ISSUE	COMMENT	RESPONSE	REFER TO
Department of Planning and Environment:			
Consistency with the original concept proposal	Given that the child-care is to be deleted from the proposal, the RtS should include a response regarding consistency with the original concept proposal in terms of provision of a community use.	Refer section 3.1 of this report for a review of the original concept proposal.	N/A
Traffic and transport	Investigate alternate upgrade works at the Pacific Highway/Grosvenor Road intersection and Grosvenor Road/Lady Game Drive intersection. Evidence of consultation with TfNSW, RMS and Council required.	Refer to the revised modelling discussed in Section 6.6 of the Traffic Assessment at Appendix J .	Appendix J
	Traffic assumptions to be updated to account for the future traffic volumes generated by a residential redevelopment of the former Screen Australia site.	Section 2.4 of the Traffic Assessment states the following: <i>'The former screen Australia site is likely to consist of no more than 100 apartments. Applying a trip generation rate of 0.19 vehicles per unit in the peak hour would result in only 19 vehicles and is deemed negligible and arbitrary in the assessment

Figure 7 Slope Assessment

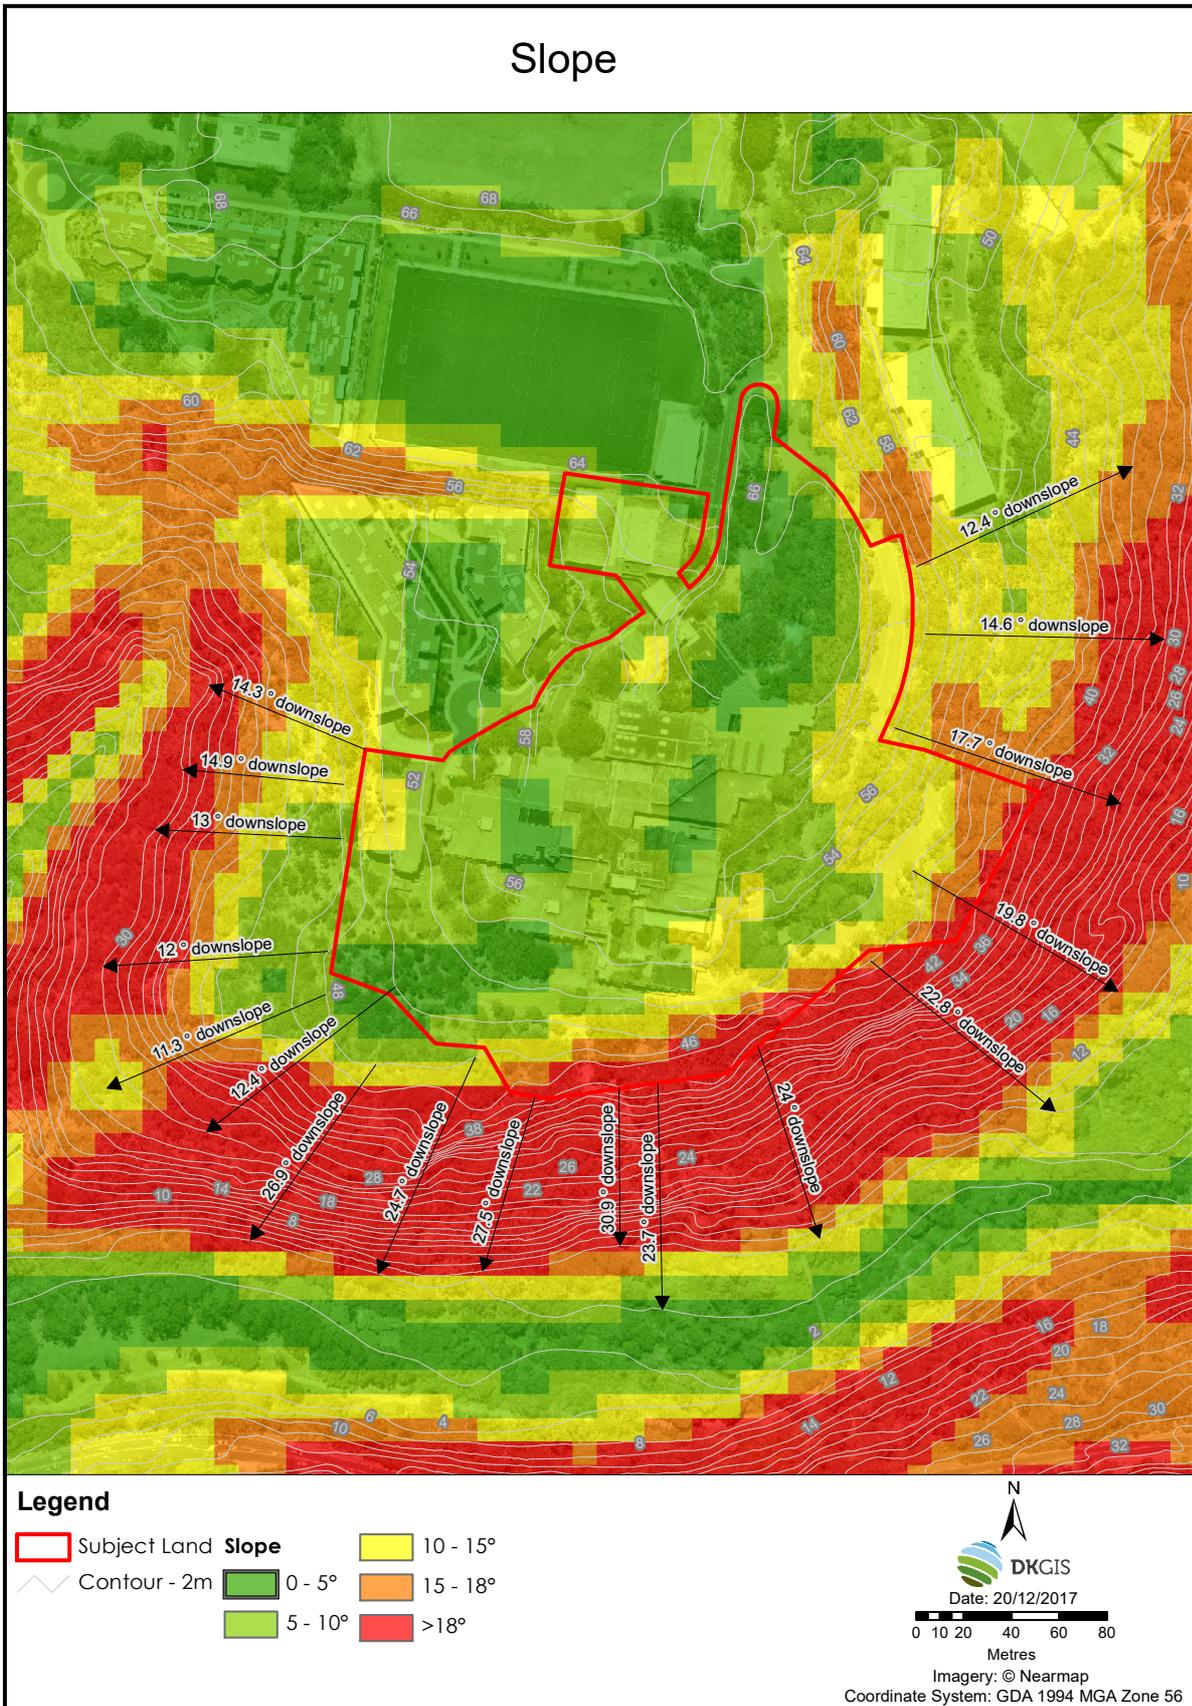
ISSUE	COMMENT	RESPONSE	REFER TO
	Additional transects should be included within the bushfire design modelling.	Additional transects are shown in Figure 7 of Appendix O to provide an indication of slope.	Appendix O
	Softfall play surfaces and synthetic turf are not covered in AS3959 and can give off various toxic by-product during the combustion process.	The areas immediately to the north of the proposed Phase 1 school building, are large public open playing fields, known as Charles Bean Oval. It is not to be used as an assembly / refuge area for students and staff due to the synthetic, and potentially hazardous, nature of material used in oval. However, it is recommended that Charles Bean Oval only be utilised as part of the evacuation/emergency planning for Lindfield Learning Village as short-term assembly / evacuation as part of the bus collection procedures when fire is not within 1 hour of the site and or embers are not observed dropping in the vicinity. If fire is within 1 hour of the site or embers are observed, Charles Bean Oval is not to be used in any capacity.	Appendix O and P

Figure 10 APZ Extent (source Kleinfelder)

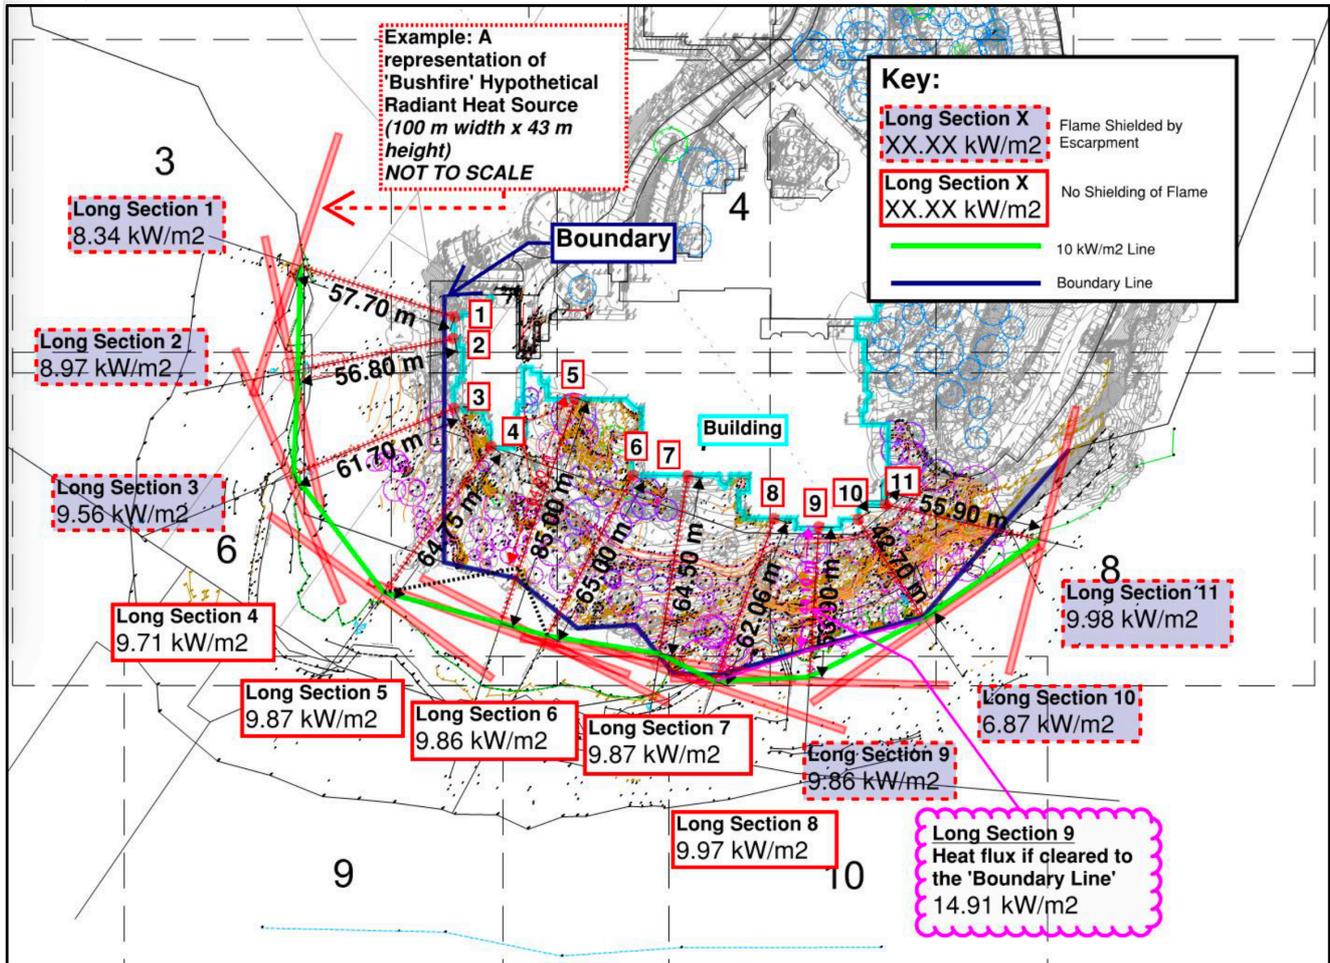
<p>Locations of APZ's on slopes of 90 degrees</p>	<p>Refer to the Bushfire Hazard Assessment at Appendix O (Figure 10) for further details on the extent and location of APZ's.</p>	<p>Appendix O</p>
	<p>The development relies APZs outside the site's boundaries which are currently not maintained to the standard of an APZ and would require significant tree removal to do so.</p>	<p>Please refer to section 2.3 of this report for a discussion of the asset protection zone for Phases 2 and 3 and vegetation management in Lane Cove National Park.</p>	<p>Section 2.3</p>
	<p>Significant vegetation removal / management is required to create the APZs onsite which has not been reflected in the EIS or accompanying Biodiversity Assessment Report.</p>	<p>The proposed vegetation clearing is addressed in the revised Biodiversity Assessment Report, Arboricultural Report, landscape plans and Bushfire Hazard Assessment.</p>	<p>Appendix C, P & O, U</p>
